**Sandstone Precinct – MOD 7 Design changes to the Education Building (SSD-7484-Mod-7)
(City of Sydney)**

Thank you for your correspondence dated 2 February 2020, requesting Transport for NSW (TfNSW) review and comment on the above.

Substation proposal

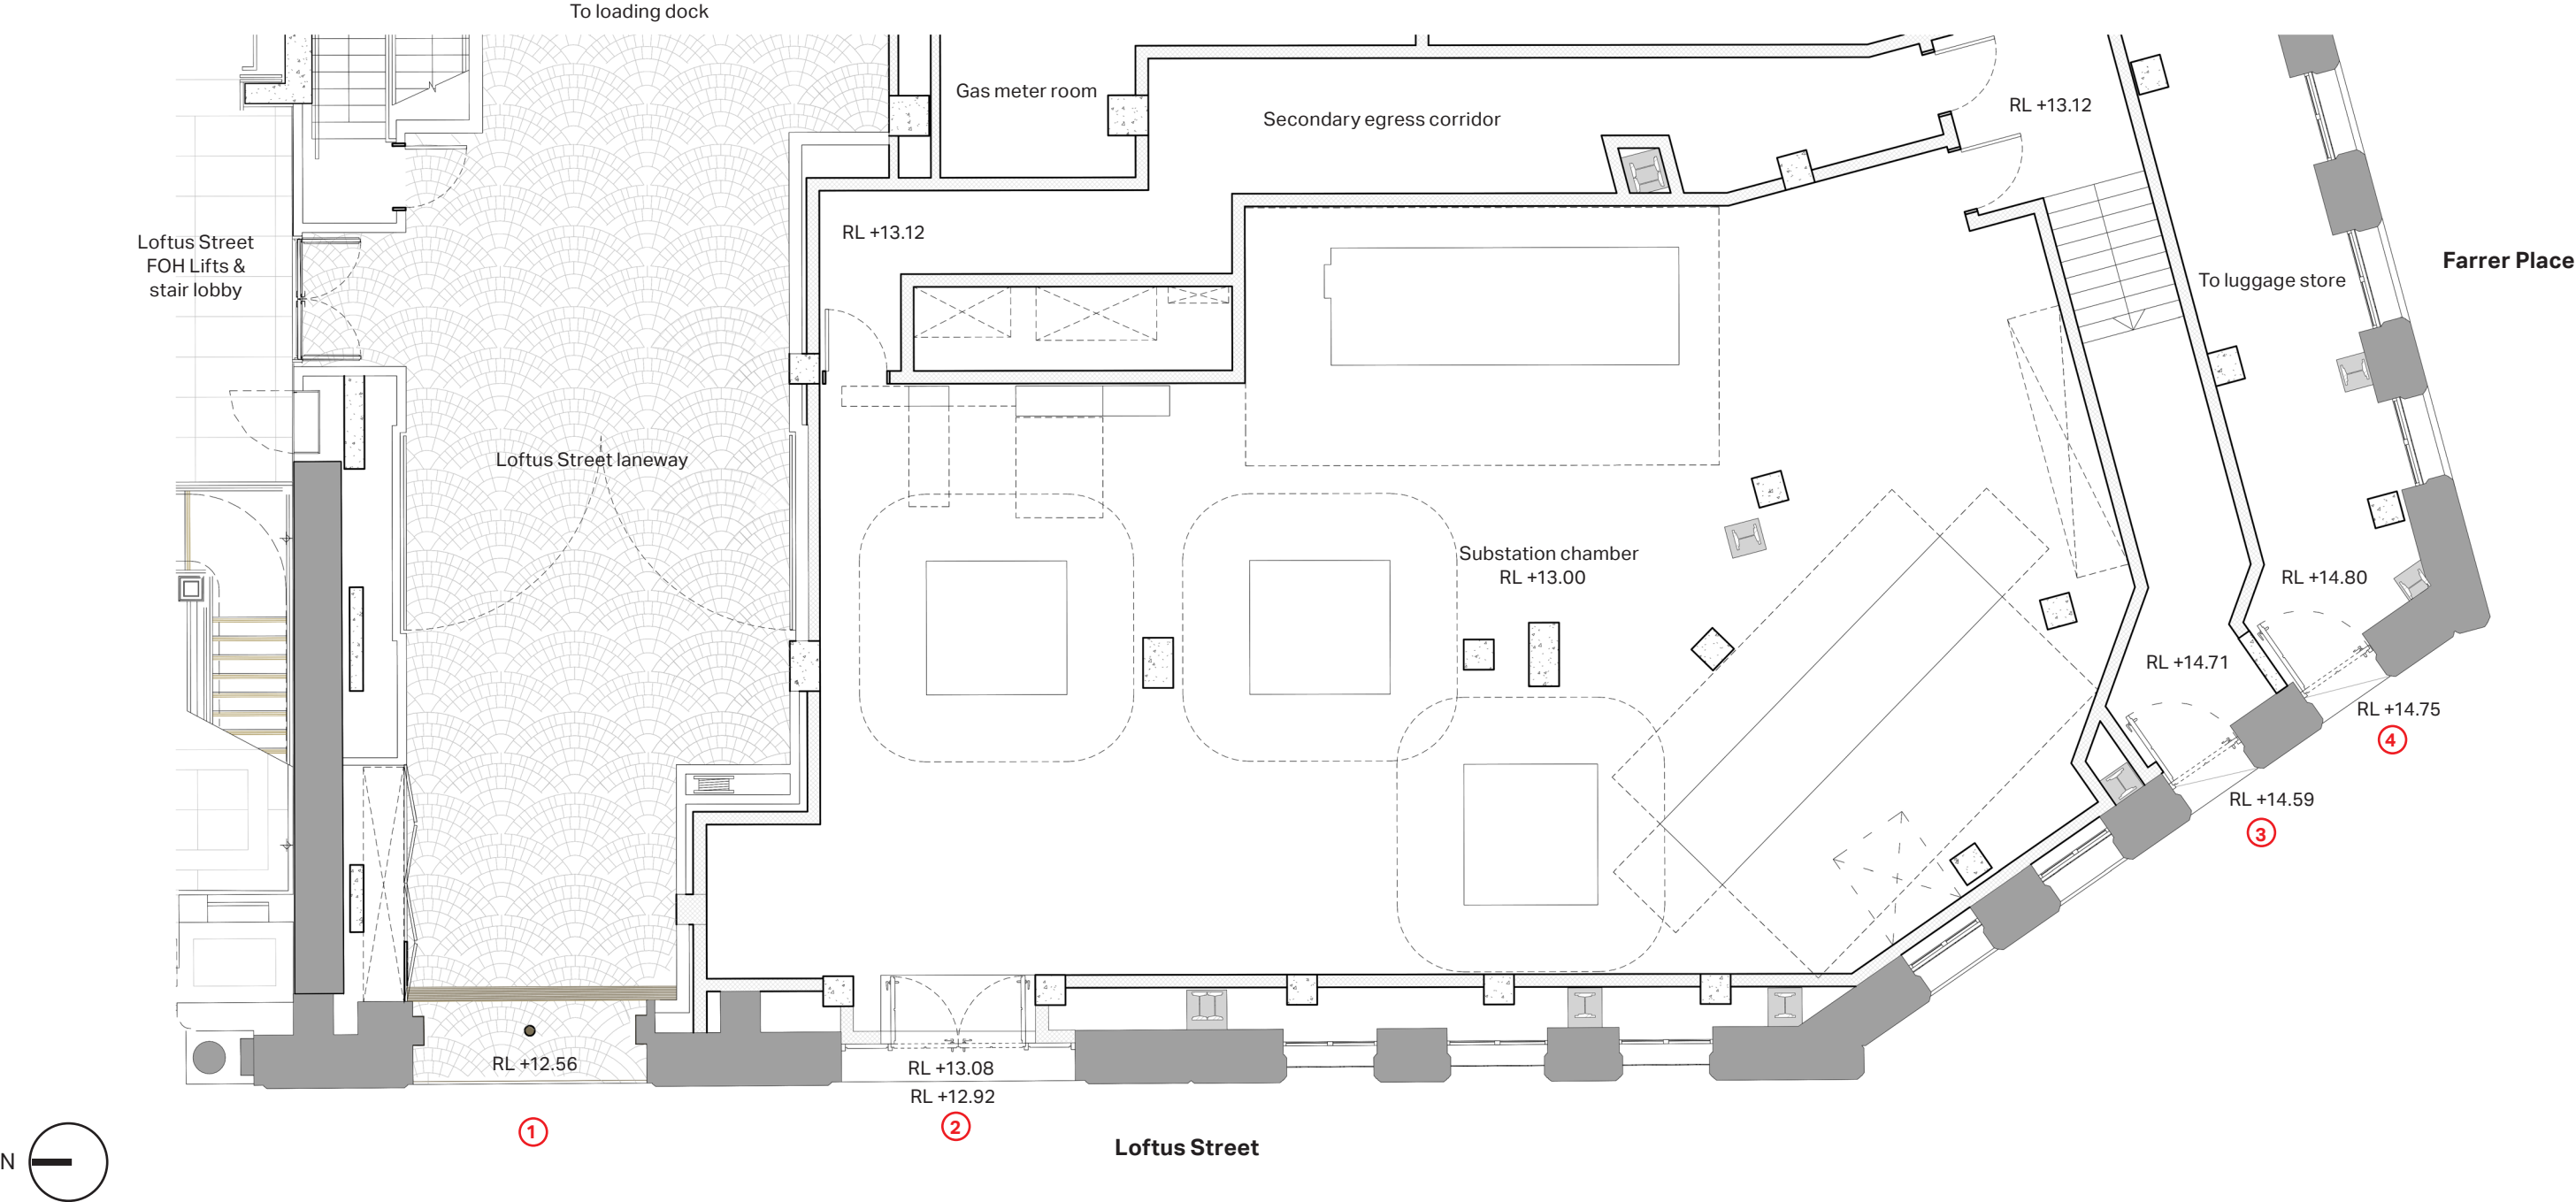
The Planning Report states the following:

- The previous design proposed DDA access from Farrer Place, through the use of a sesame stair. This is proposed to be removed, with at grade access now proposed through the Loftus Street Laneway on the western side of the building; and
- Pedestrians will also have right of way at all times, as the laneway is also used for vehicular entry to the loading dock.

Prior to the issue of the Construction Certificate for Modification 7, the applicant shall be conditioned to ensure the vehicular entry to the loading dock and DDA access through the Loftus Street Laneway is managed so as to ensure freight and servicing vehicles do not impact traffic movement on Loftus Street. The applicant shall demonstrate to the Sydney Coordination Office

that the loading dock and DDA access through the Loftus Street Laneway is managed so as to ensure freight and servicing vehicles do not impact traffic movement on Loftus Street.
